From: Neil Whitton
Sent: 08 November 2021 12:28
To: David Lowin
Cc: DC Support
Subject: 21/03267/OUT - Os Parcel 0006 South East Of Baynards House Adjoining A43, Baynards Green, Oxfordshire

Environmental Protection has the following response to this application as presented:

Figure 10.3: Noise Mitigation – 2m Noise Barrier

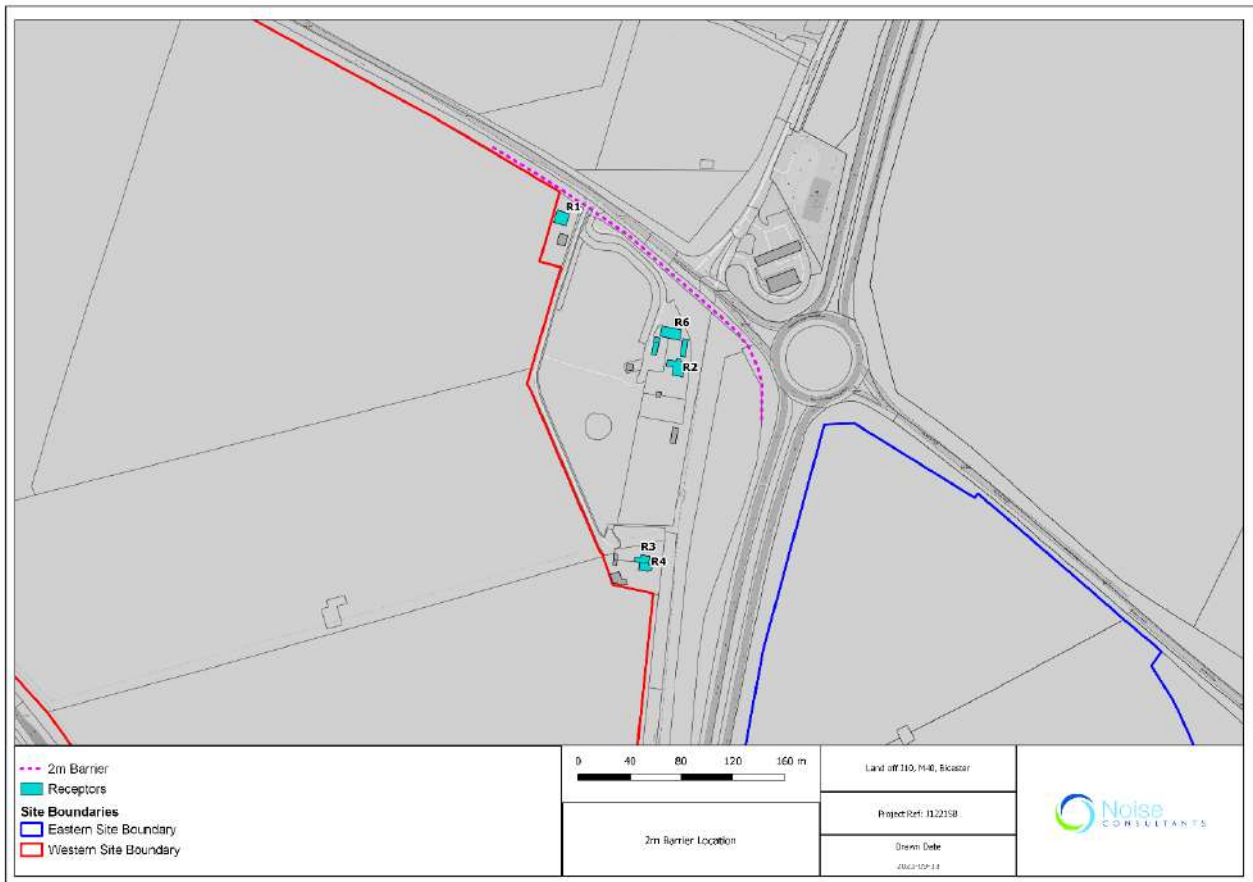
Having read the noise chapter of the ES I believe that as much as possible should be done to limit the noise impact of the nearby residential properties. I would therefore recommend that both the noise barrier in para 10.7.25 and the low noise road surfacing to achieve a further noise reduction of 3dB in para 10.7.29 be implemented should the scheme be granted permission by condition. In addition further mitigation developed as part of the final design should be supplied to and approved by the LPA prior to development commencing.
